CITY OF PORTLAND, MAINE  
 DEVELOPMENT REVIEW APPLICATION  
 PLANNING DEPARTMENT PROCESSING FORM

103 Herman Island

Project Name/Description

**Approval Conditions of DRC**

SITE PLAN

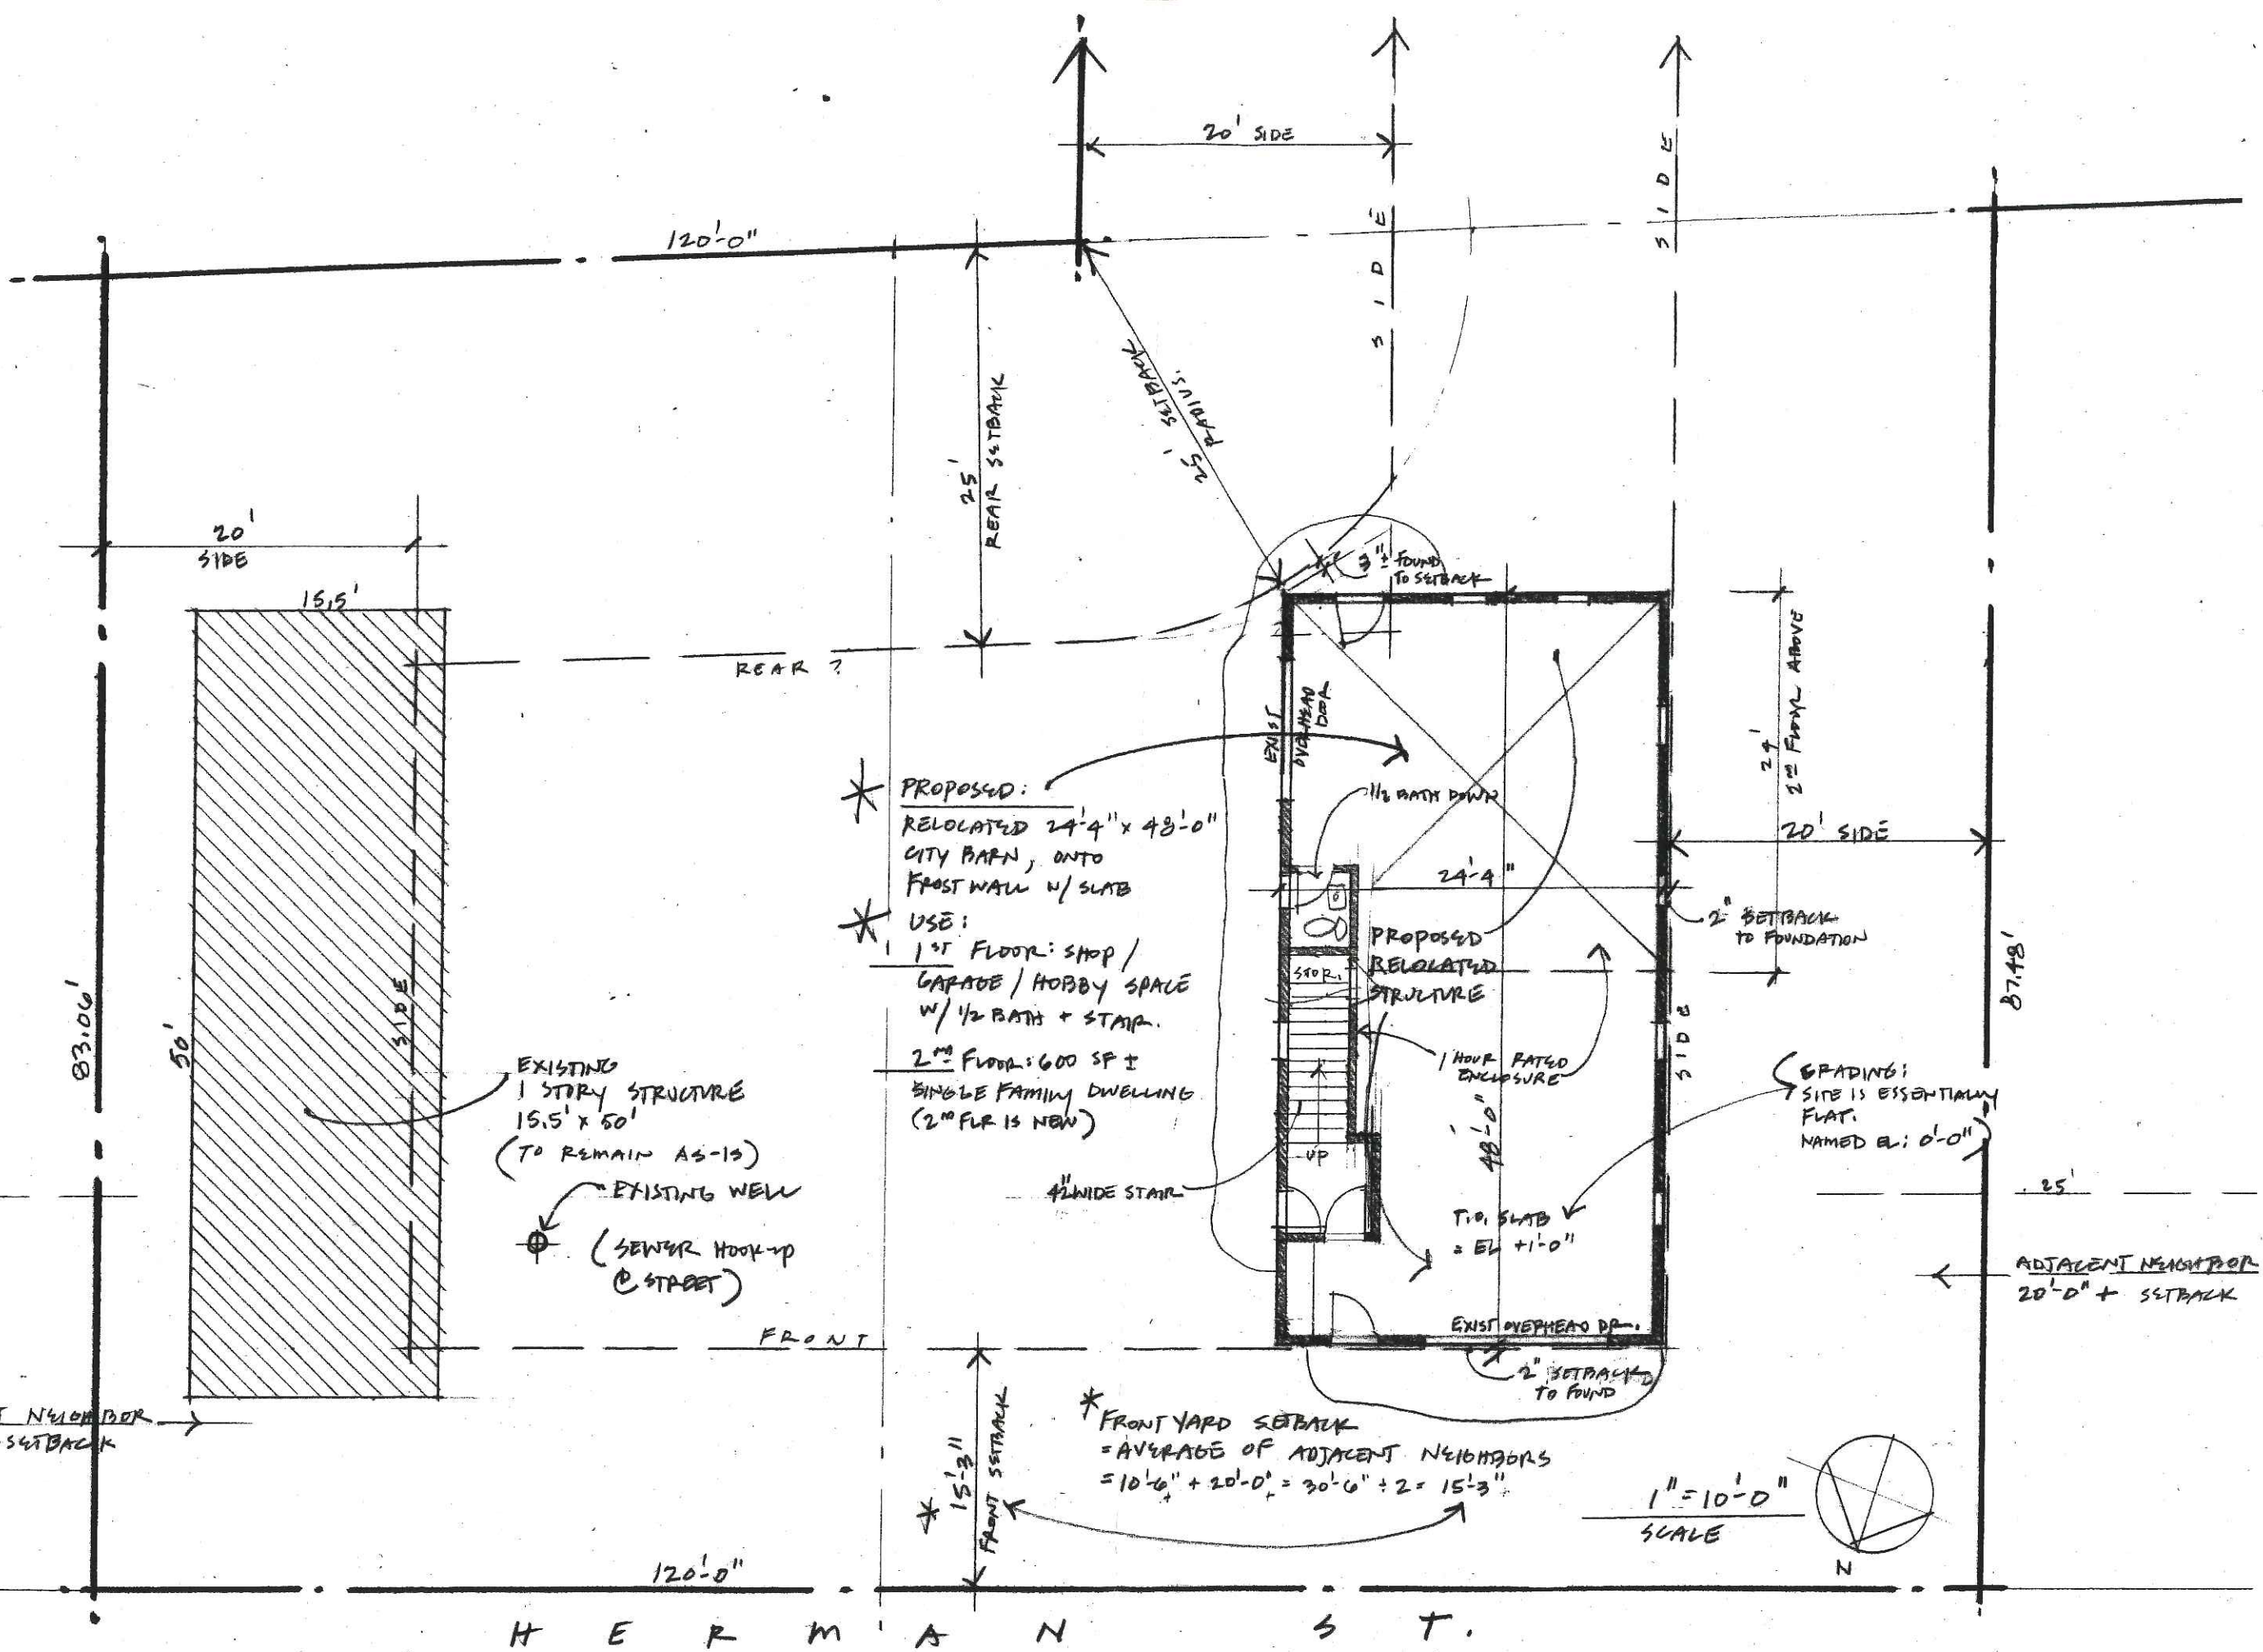
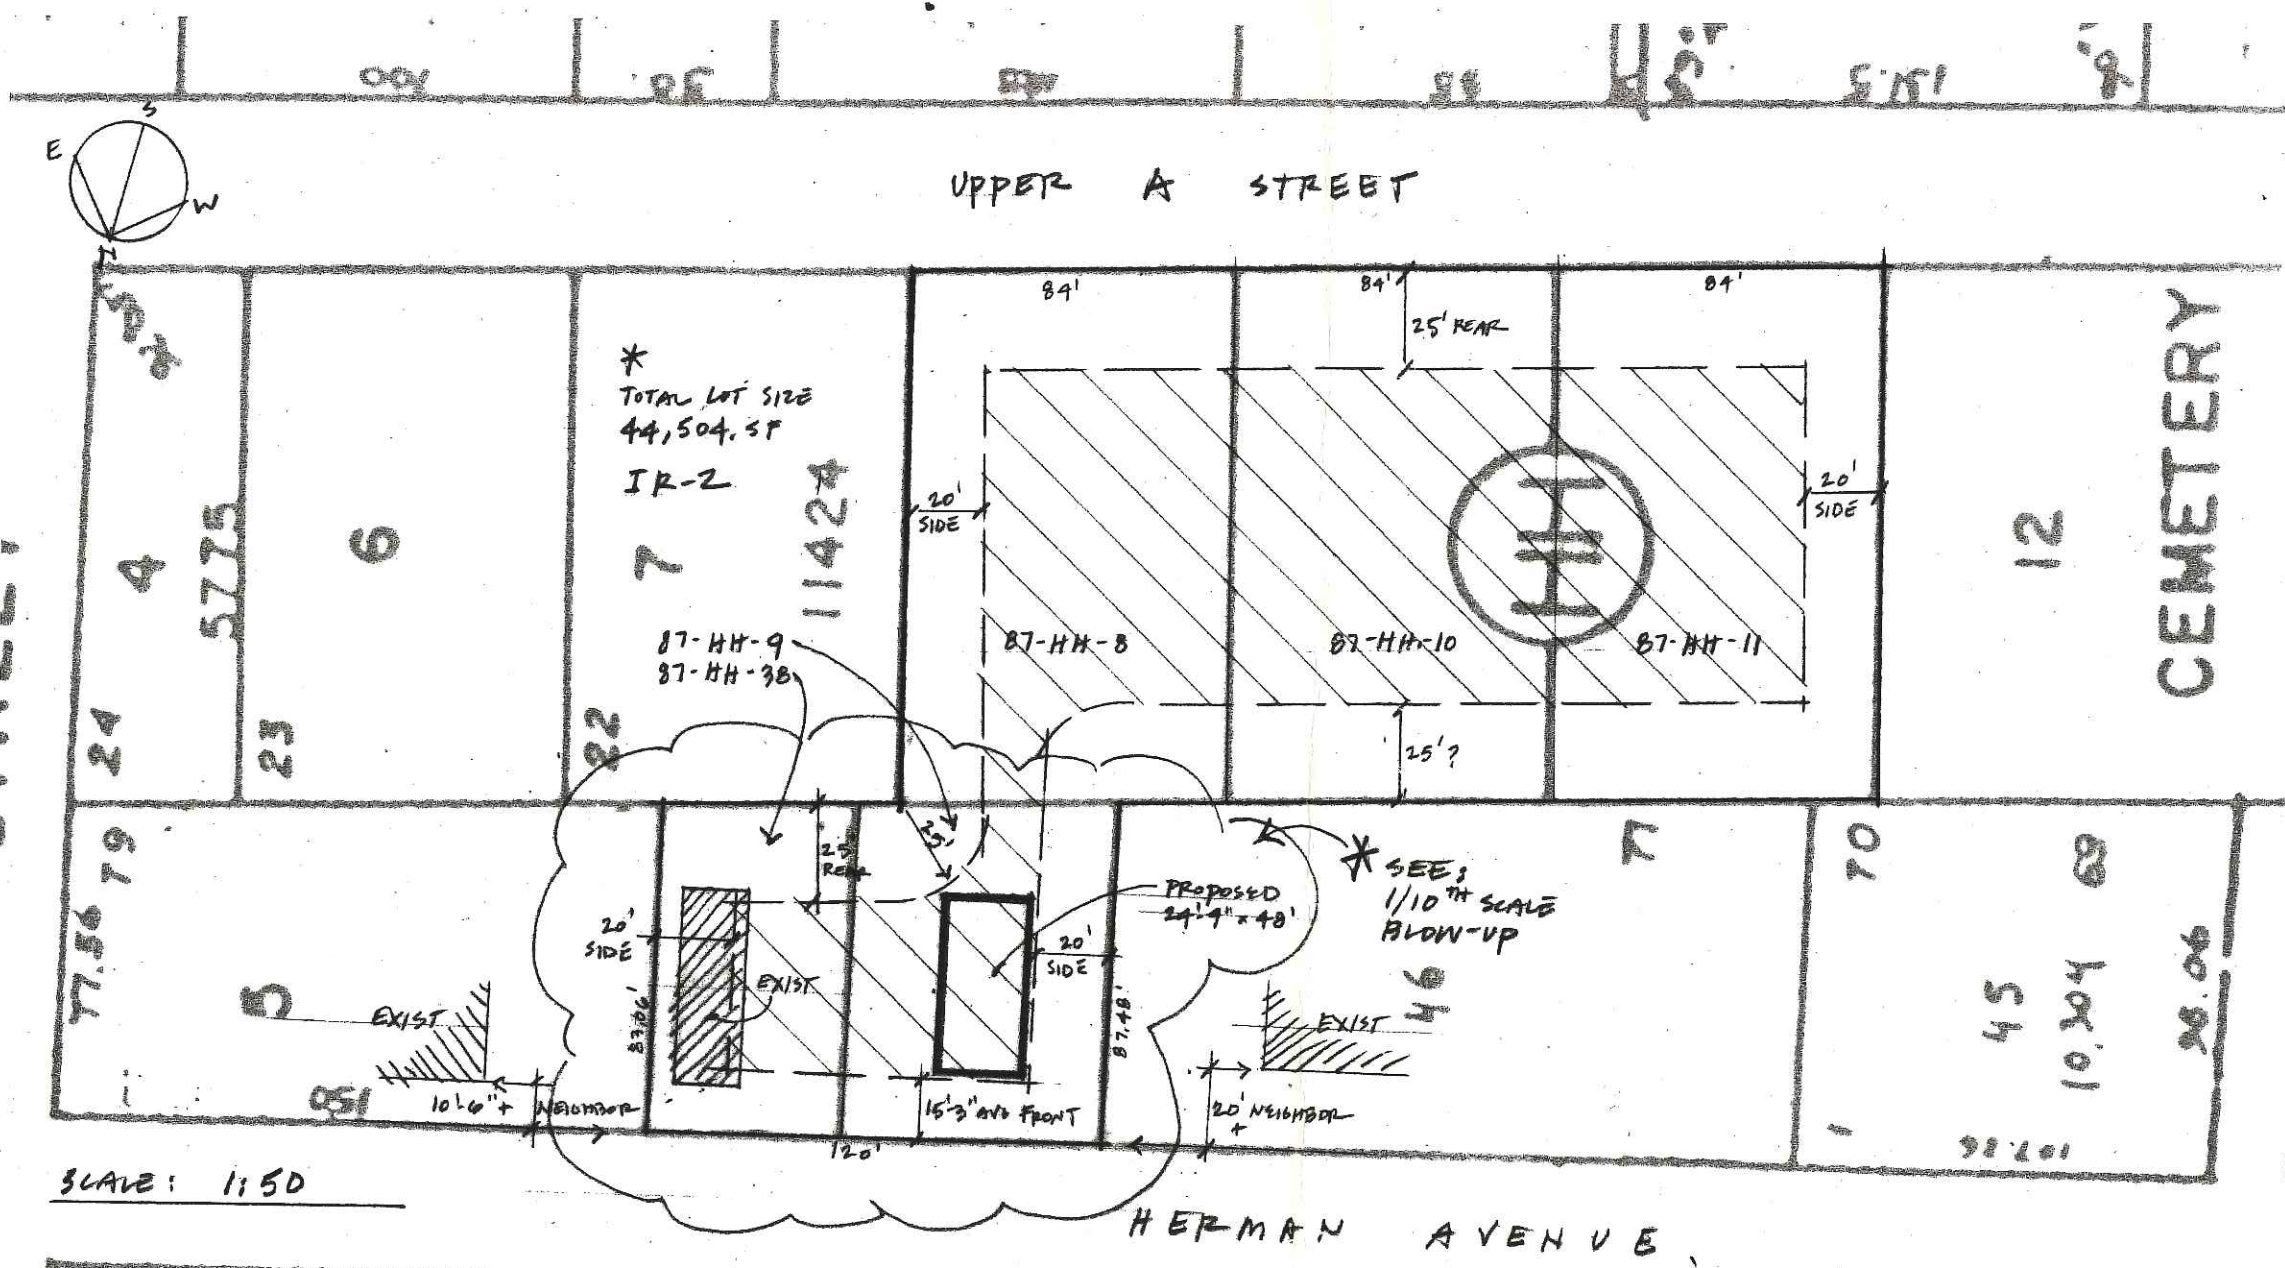
*ex. / Prop. Grades (none shown)  
 Does AD own All Panels  
 Show Well + Sewer + Water Services  
 2 street trees  
 IS Make All Set up, Streets +  
 Utility Lines Lot Line?*

- 8 The site contractor shall establish finish grades at the foundation, bulkhead and basement windows to be in conformance with the first floor elevation (FFE) and sill elevation (SE) set by the building contractor to provide for positive drainage away from entire footprint of building.
